**From:** Sue Howell  
**Sent:** 01 August 2018 16:20  
**To:** Planning.Responses  
**Cc:** Anita Gardner  
**Subject:** RE: Planning Consultation on: A/74/18/OUT

**APPLICATION A/74/18/OUT**

**Site Address:** The Laurels Dappers Lane Angmering BN16 4EN

**Description of Works:** Outline Planning Permission with all matters reserved, except access, for the demolition of existing outbuildings and the erection of 9No. two storey dwellings consisting of 2No. two bedroom dwellings, 3No. three bedroom dwellings and 4No. four bedroom dwellings. Departure from the Development Plan.

Drawing name:
Master Plan For 9 Units

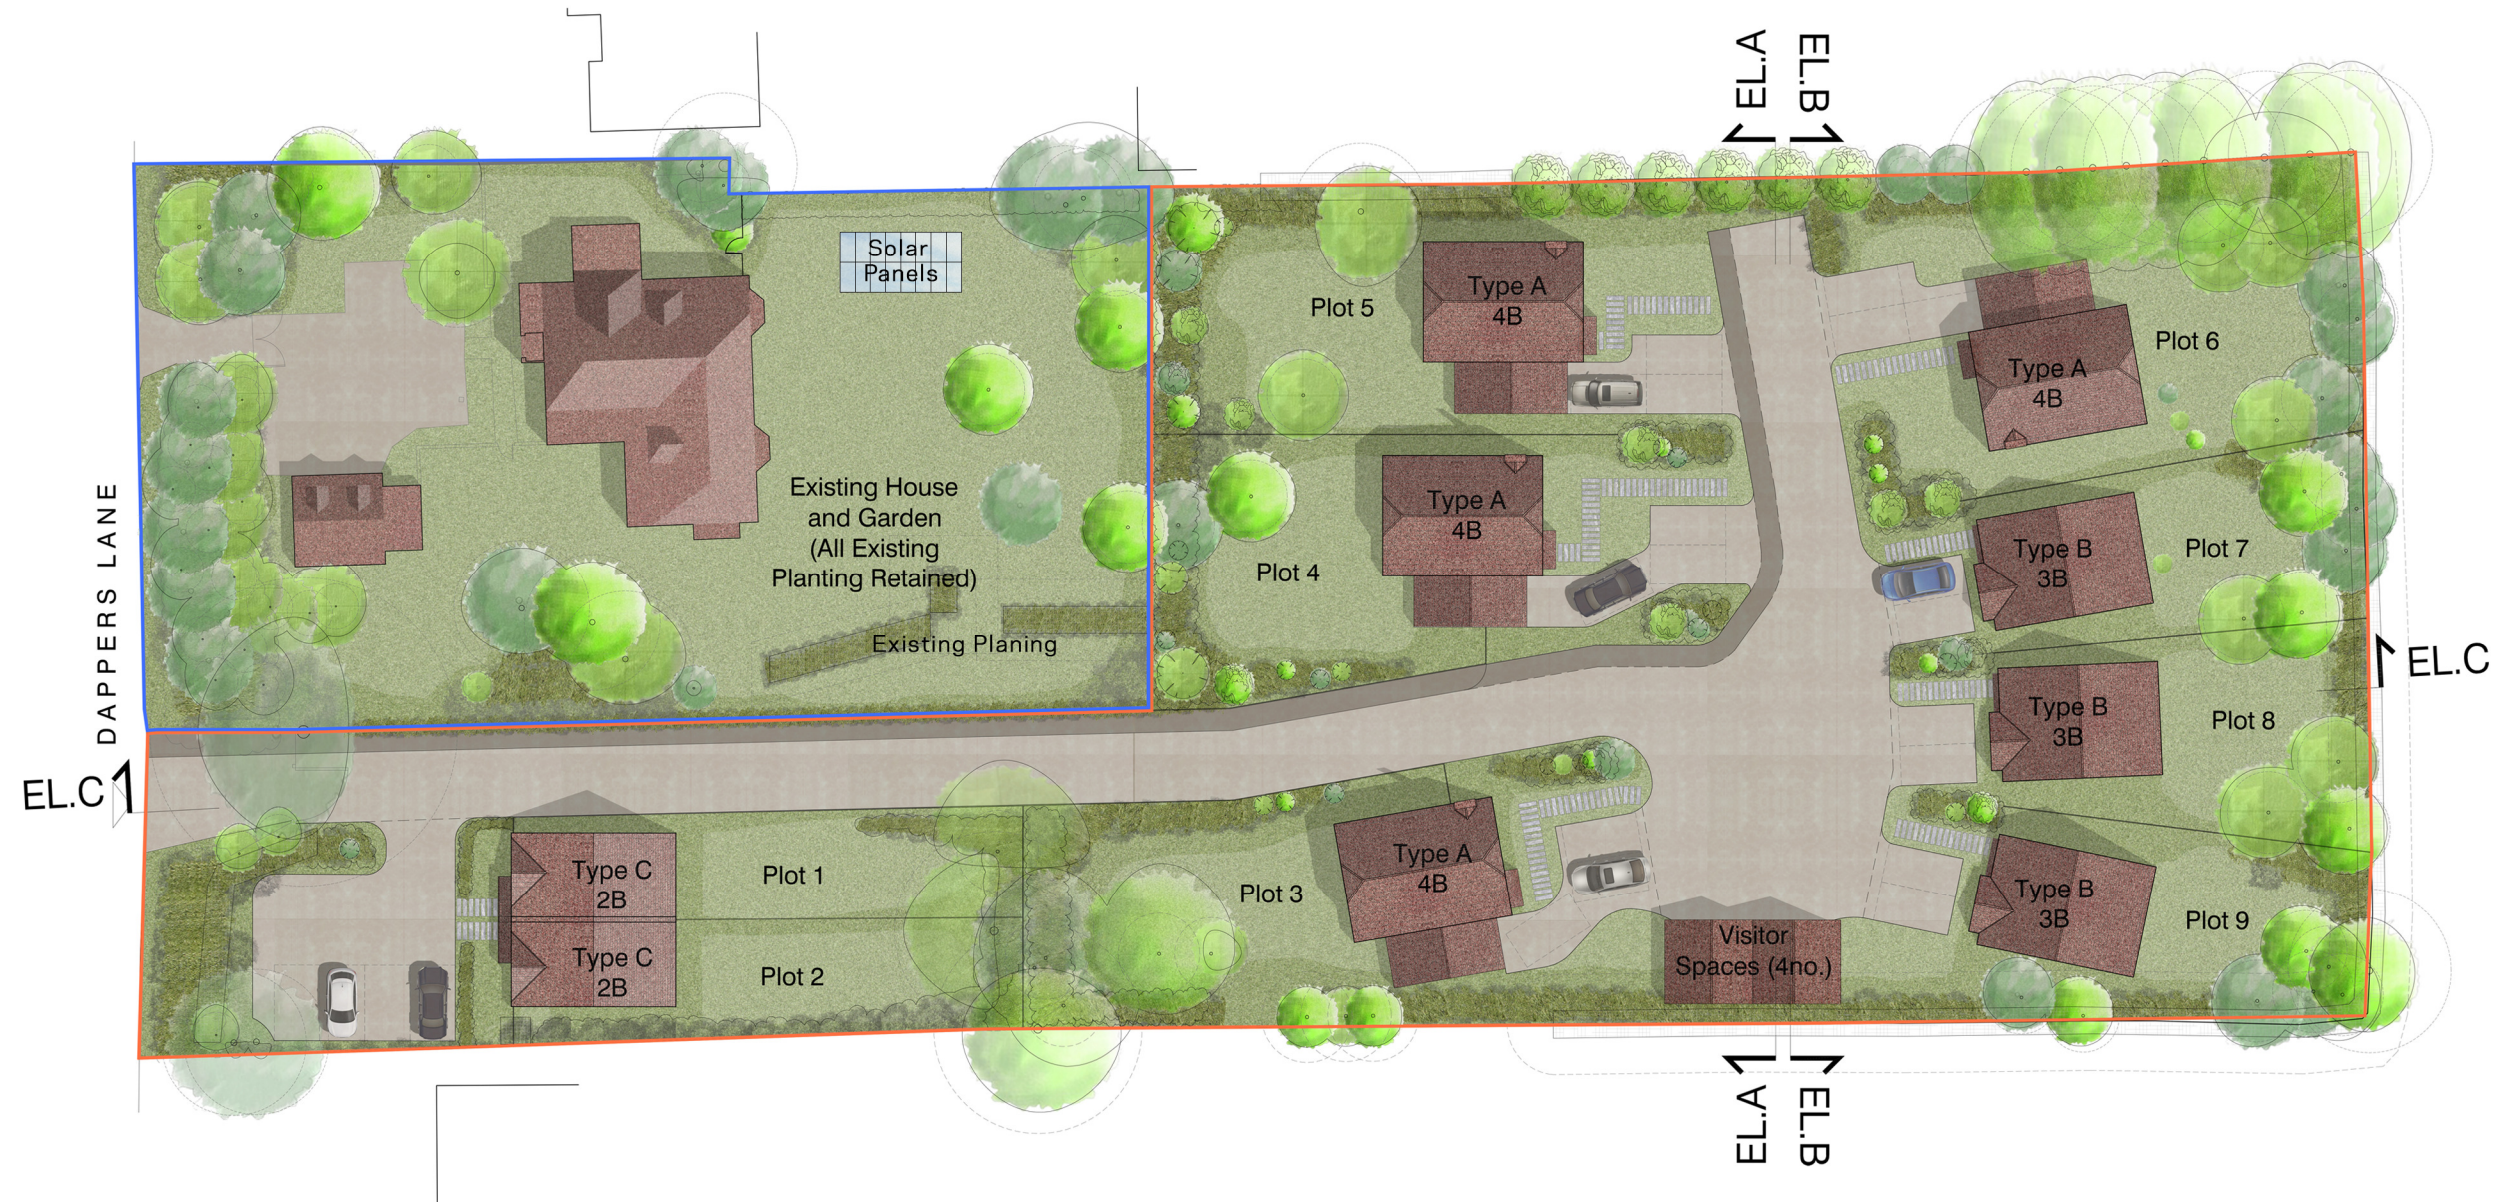
A development of any size would benefit from the inclusion of landscaping to soften the development and allow it to fit within the environment and provide appropriate screening to adjacent existing properties. The Design and Access statement section 6 shows an indicative scheme, however a detailed landscape scheme will need to be proposed that will maximise the biodiversity of the site, with the inclusion of mixed ornamental planting suitable for location, enhancing biodiversity and forming a variety of habitats. The landscape proposals will need to be shown in plan from detailing species choice, planting densities and size at time of planting. This will need to include mitigation planting for any proposed removed vegetation and possible additional planting to provide appropriate screening to adjacent properties. These details are required to ensure the adjacent properties privacy is maintained and the setting is uncompromised. As a minimum this will need to be conditioned with any decision.

Any proposed tree works to this site should be in consultation with agreed with Arun District Councils Tree Officer. The existing vegetation in some places is established, where these areas and trees are significant they will need to be protected and retained. Before construction a tree protection scheme must be in place for all retained trees including trees whose root protection areas fall within the construction zone from neighbouring properties. This should be in accordance with BS 5837(2012) 'Trees in relation to construction'

I would recommend no landscape objection subject to the submission (or condition applied) for approval of information detailed above.
